Design Review Panel- ACTIONS

Meeting number: Meeting 10 - 2014

Date: 31 October 2014

Location: Lend Lease Offices, Level 15, 201 Kent Street Sydney

Figure 7.7 – Podium West Elevation

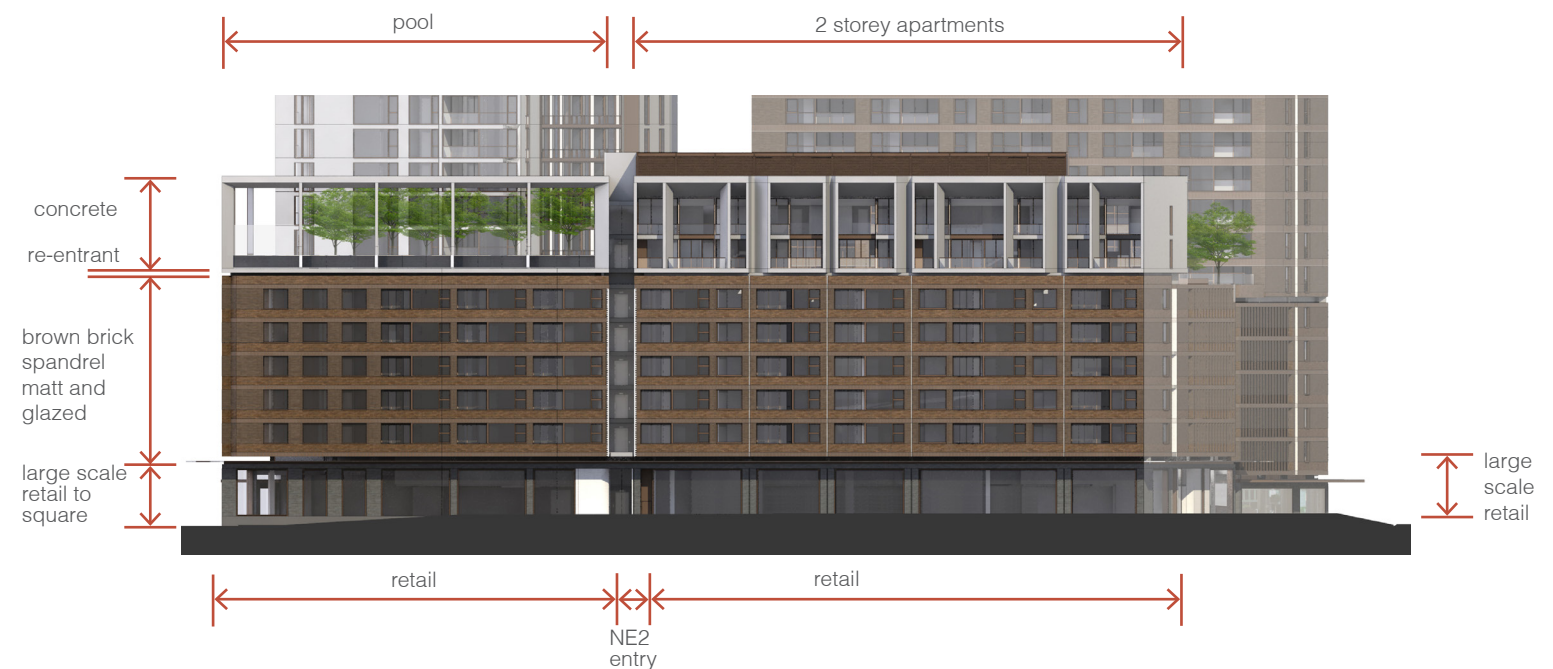
1.3	Building Form - 4 major parts – podium and 3 towers - Currently there is no architect selected for SE plot - Square and laneways designer still to be appointed from select group. - Language of brickwork - texture with use of matt and gloss Podium - Balconies are inset – use of screens – white glazed tiles, interlocking bricks - Double height apartment of NE2 to be from painted concrete rather than off form. - The panel noted that the lower floors of the podium looked “heavy” in the artist impressions. The impressions may not show true texture of building.	Note
